December 18, 2023

**Re: Mister Car Wash
2160 Gibson Blvd SE
Request for Certificate of Occupancy- 30 Day Temp
Transportation Development Final Inspection
Engineer's Stamp dated 12-1-22 (M15D021B)
Certification dated 12-8-23**

SHEET NUMBER
C500

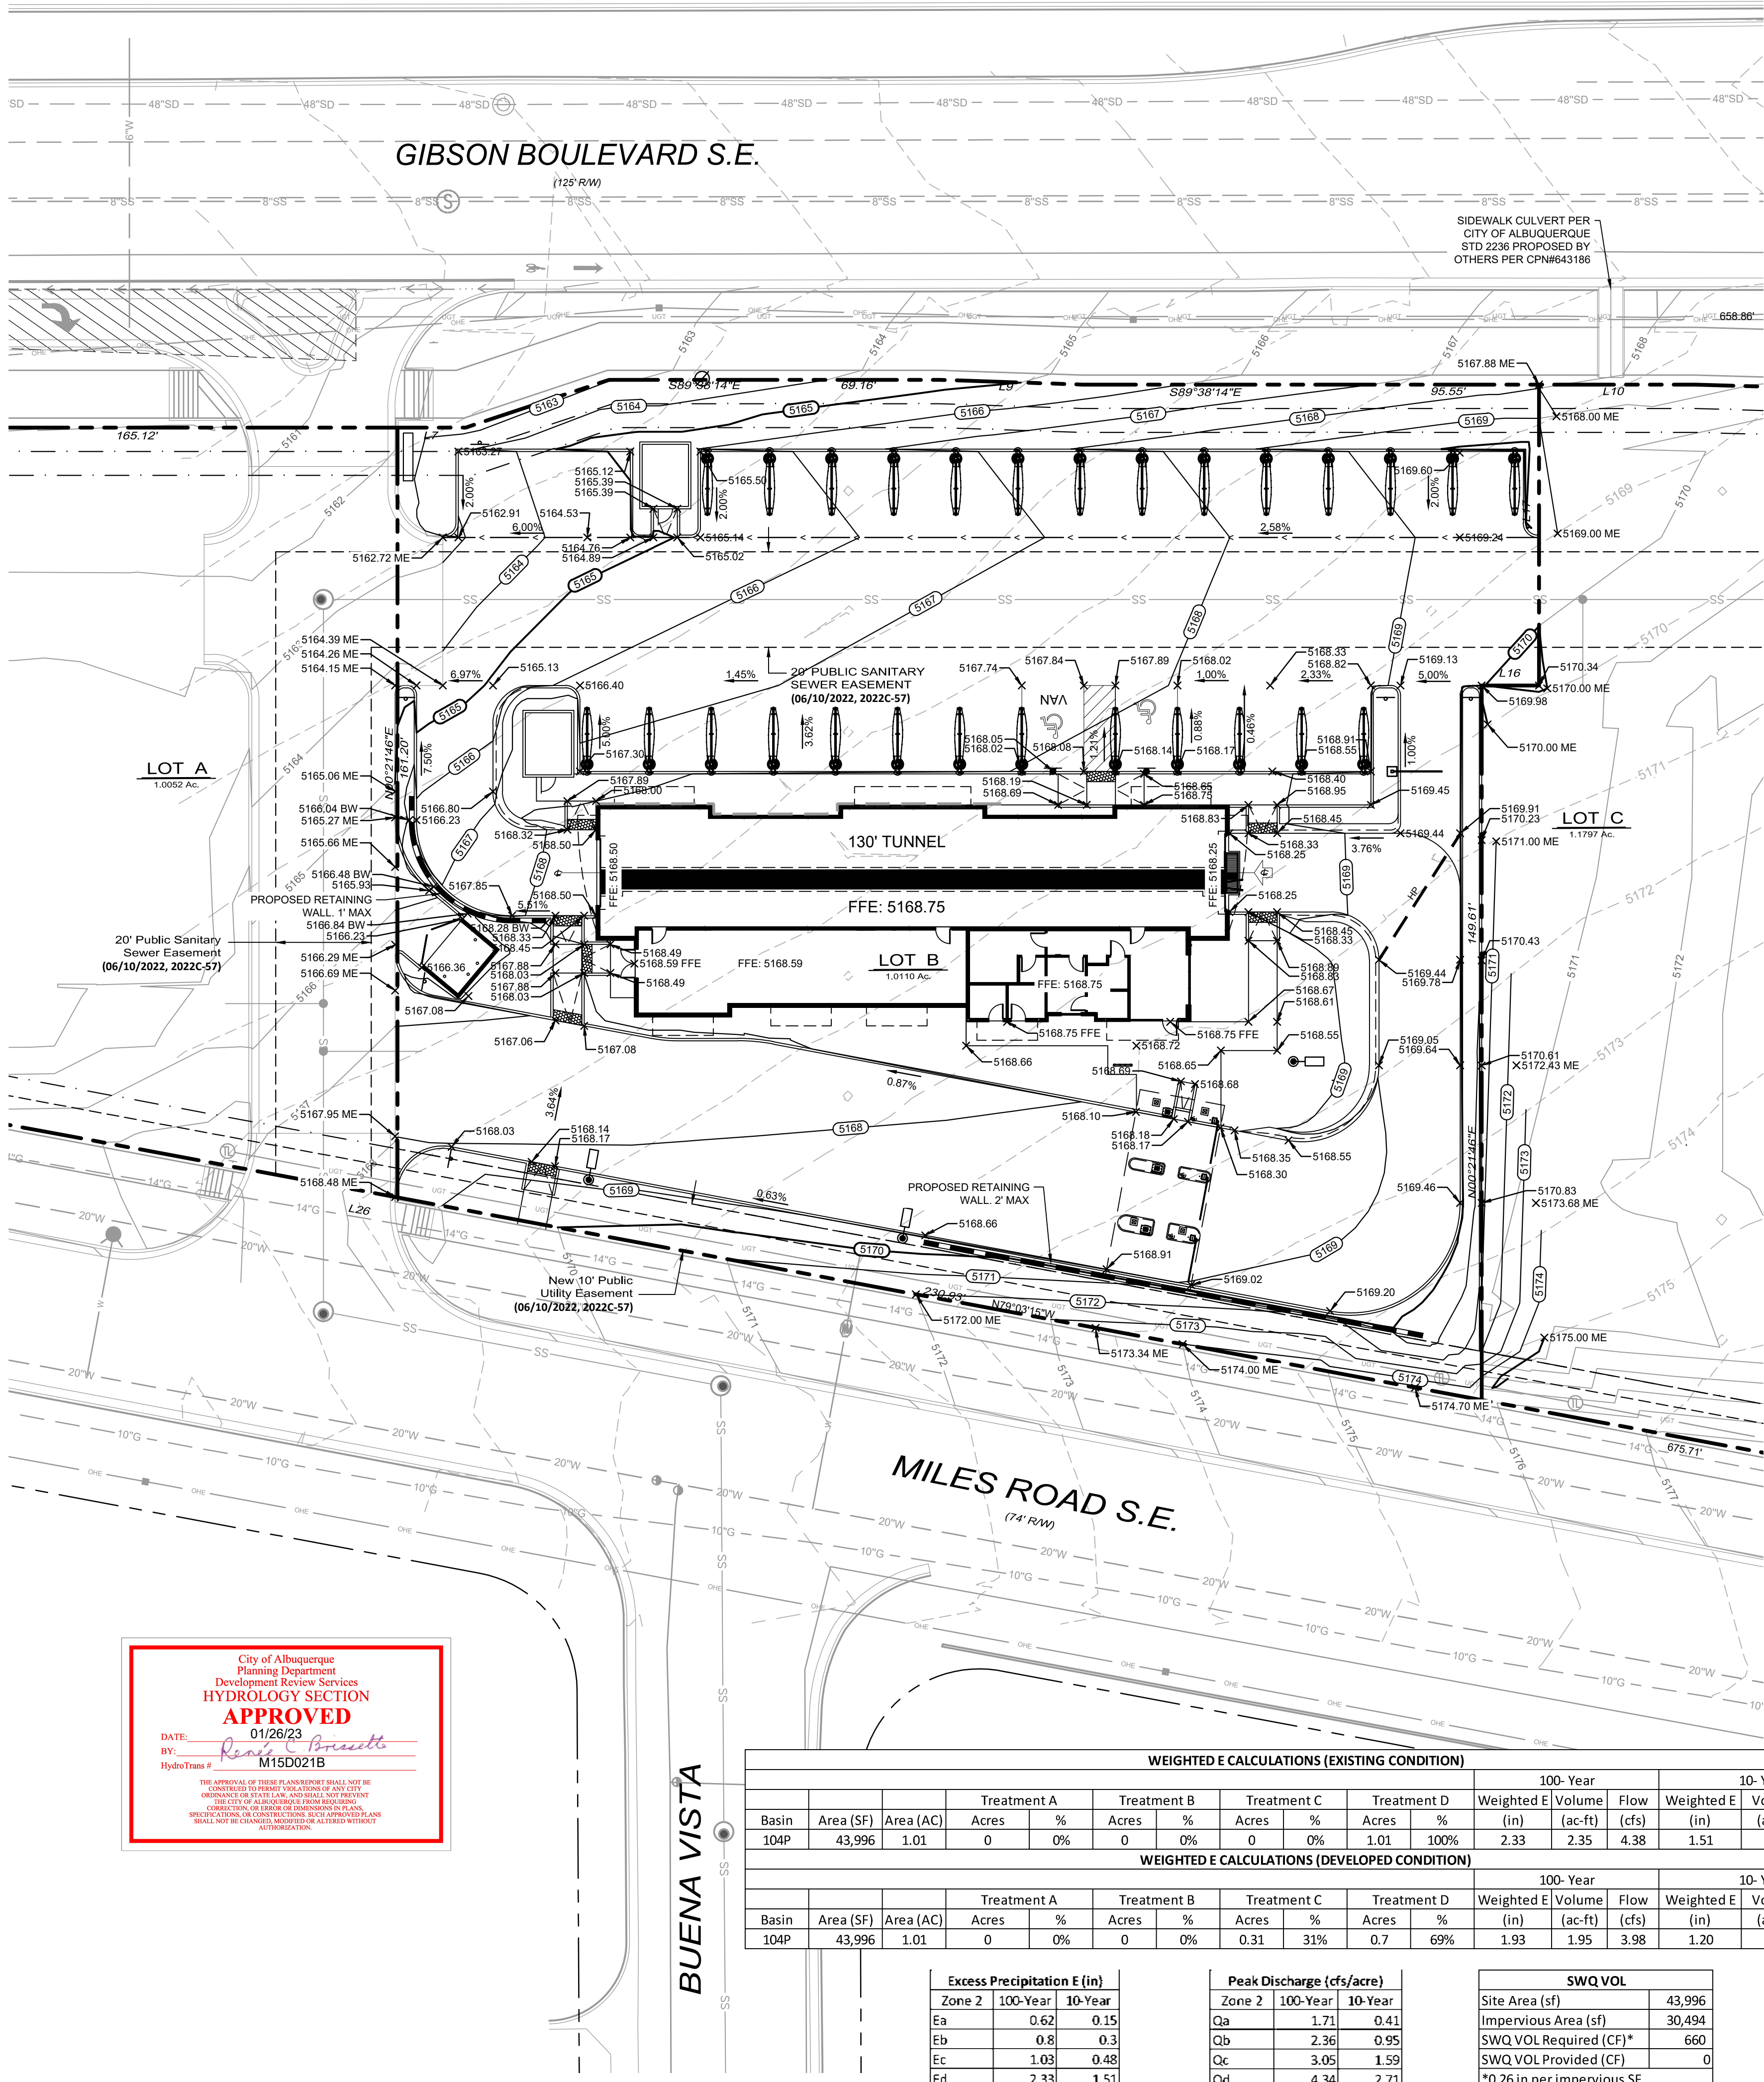
1. A handrail is to be constructed (on private property) along the sidewalk where the new ramp was built as there is a drop-off adjacent to the public sidewalk. Length of handrail to be the length of the ramp/grade difference.

2. Replace two public sidewalk stones adjacent to the ramp discussed in #1 above. One stone has a chunk missing and the other stone has a transverse crack across the entire stone.

3. Provide an asphalt paved driving surface at the east end of the Cross Access easement. Currently, there is a step grade change varying from approximately 3" to 10" as the site was built higher than the existing grade east of it.

4. Construct the pavement markings. The striping Contractor was onsite during my inspection, but had not finished the work.
5. Provide the "Do Not Enter" and "One-Way" signage.

6. Remove the sediment from the paved trail along Gibson Blvd.
7. Replace the sediment-laden aggregate in the landscape buffer with clean aggregate.
8. Provide a record Drawing that shows the as-built condition of the site (e.g. new ramp design and handrail).
